PLANNING CONSULTATION RESPONSE

Application No	2026/0298
Proposal	Change of use of upper floors from storage to create 3x flats (Use Class C3) including conversion of roof space and installation of rooflights.
Address	36 Hoyland Road, Hoyland Common, Barnsley, S74 0PB
Date of Consultation Reply	5 th June 2026
Consultee	Highways DC

[2nd response]

Proposed site plan
Scale: 1 : 200

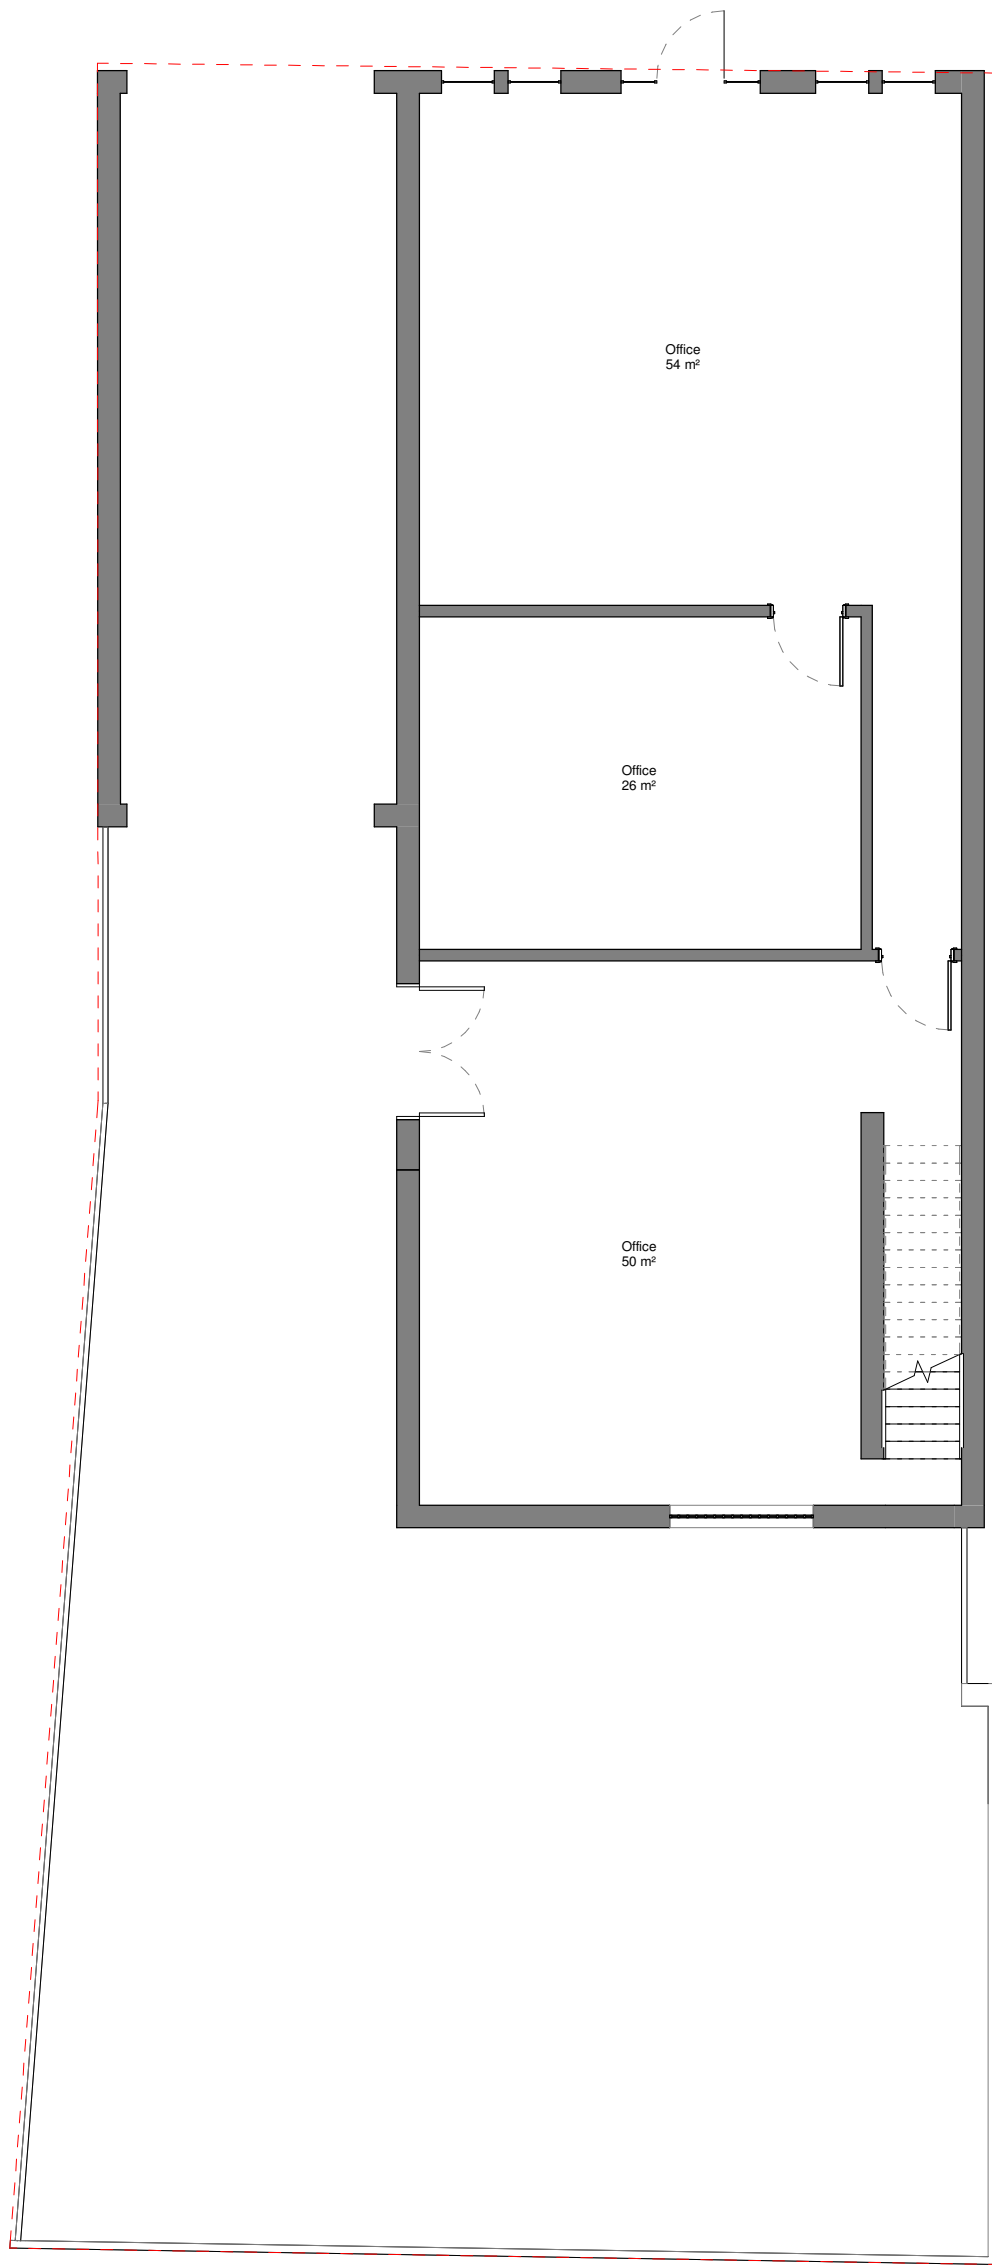
The proposed site layout now includes 3no. parking spaces of the required 2.5m x 5m dimensions. A cycle storage facility of sufficient size to accommodate at least three bicycles (one per flat) is to be provided within the rear yard area, this would serve to encourage means of travel other than the private car, improving the sustainability of the site.

Although the first floor of the building appears to have previously been used as a storage facility for the ground floor offices, the 134m² area would presumably fall within the same office use classification, thereby requiring 4no. off-street parking spaces (1 space per 30m²).

The submitted information states that the offices on the ground floor have been vacant for approximately two years, however, they could of course be brought back into use at any time. The ground floor comprises 130m² of office use which therefore requires 4no. parking spaces; the total parking requirement for the existing office use of the building is 8no. parking spaces. The rear yard area cannot accommodate this number of vehicles which means that the site has previously operated with insufficient off-street parking facilities without having a detrimental impact upon the public highway.

The proposed use of the first floor (and second floor roof space) to create three flats would result in the requirement to provide 3no. off-street parking spaces. Given that the existing use of the first floor requires the provision of 4no. parking spaces, it is evident that the proposals would not result in an increase in demand for parking provision when compared with the potential for the building to be fully utilised within its current use classification.

The access, parking and manoeuvring facilities, indicated on the submitted plan, shall be surfaced in a solid bound material (i.e. not loose chippings) and made available for the access, parking and manoeuvring of motor vehicles prior to the development being brought into use, and shall be retained for said purposes at all times.

Prior to the development being brought into use, the scheme for the parking of bicycles as shown on the submitted plans shall be fully implemented and thereafter retained for this purpose.
